## Fosse Green Energy - EN010154

## Section 51 advice regarding draft application documents

Issued on 13 June 2025

Sheet 5 of 16

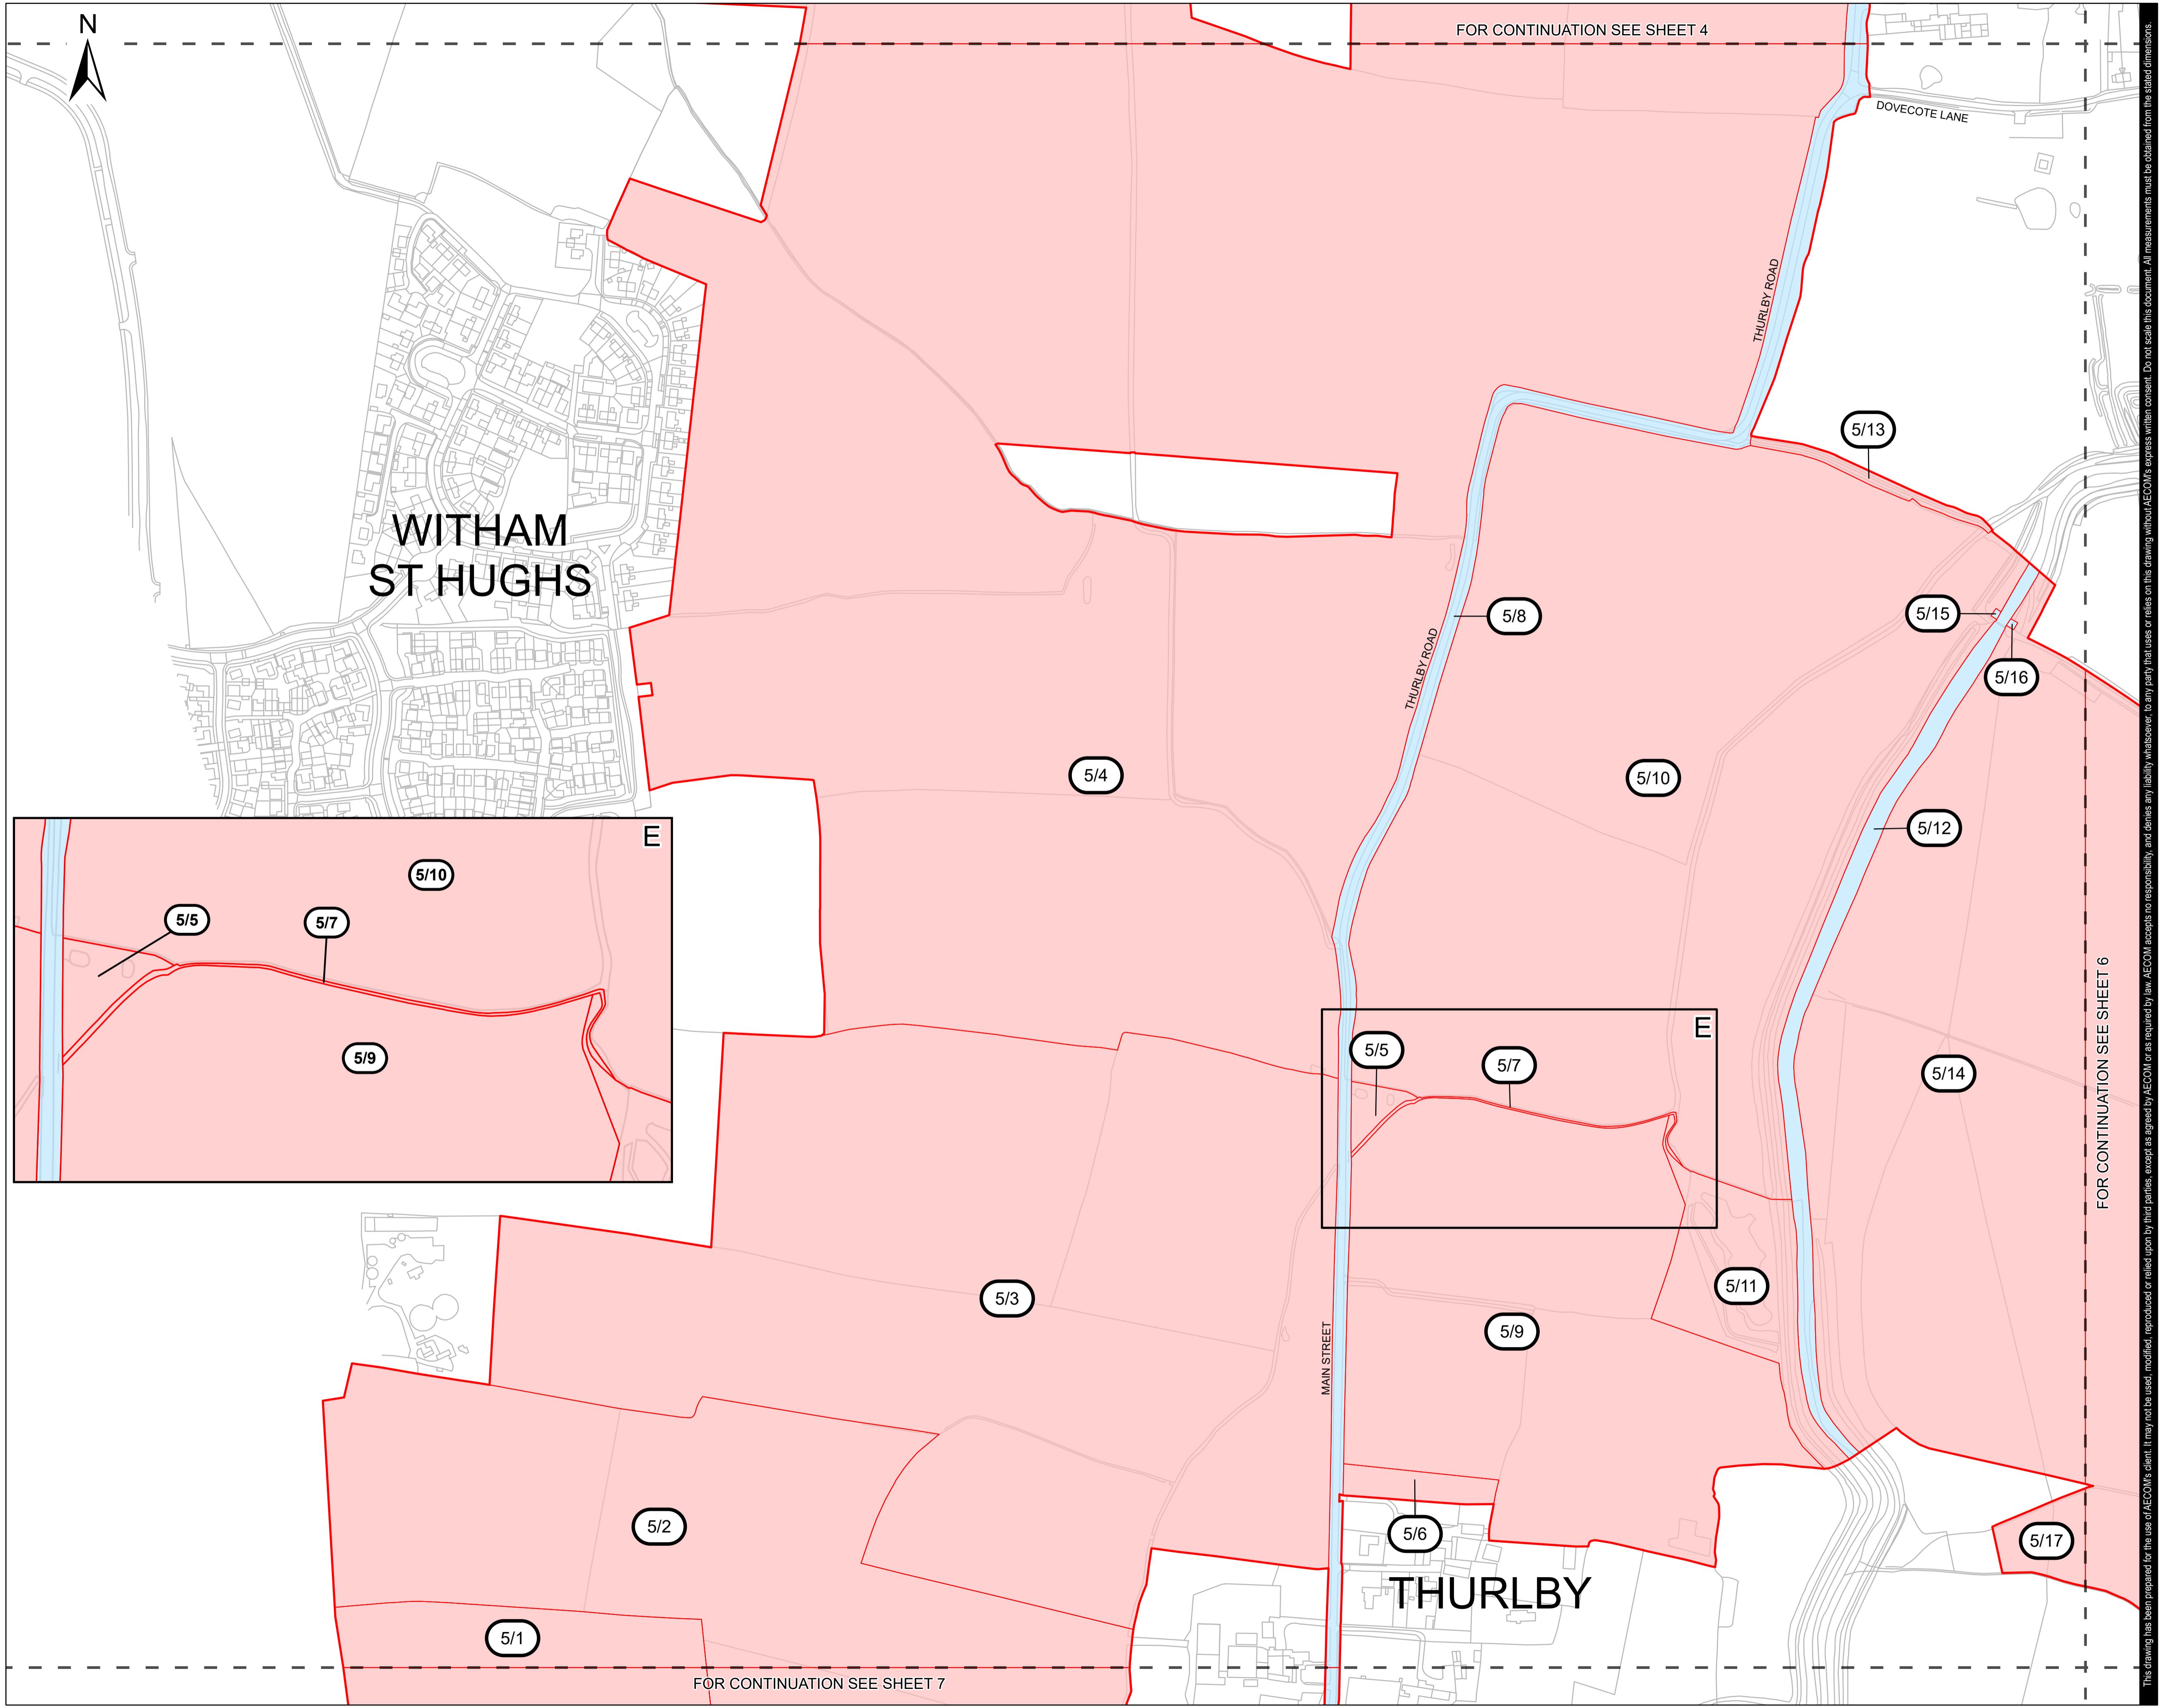
4.	All plans	No temporary acquisition of land plots listed in the key or plans.
5.	<b>Sheets 5 and 6 Plots 5/16, 5/17, 6/1</b>	Its not clear where the boundaries are, as there are no dark lines splitting the plots. Additionally, the plot number change on the next sheet, when it appears that it should be the same plot of land (given that there is no demarcation separating them except the sheet number).
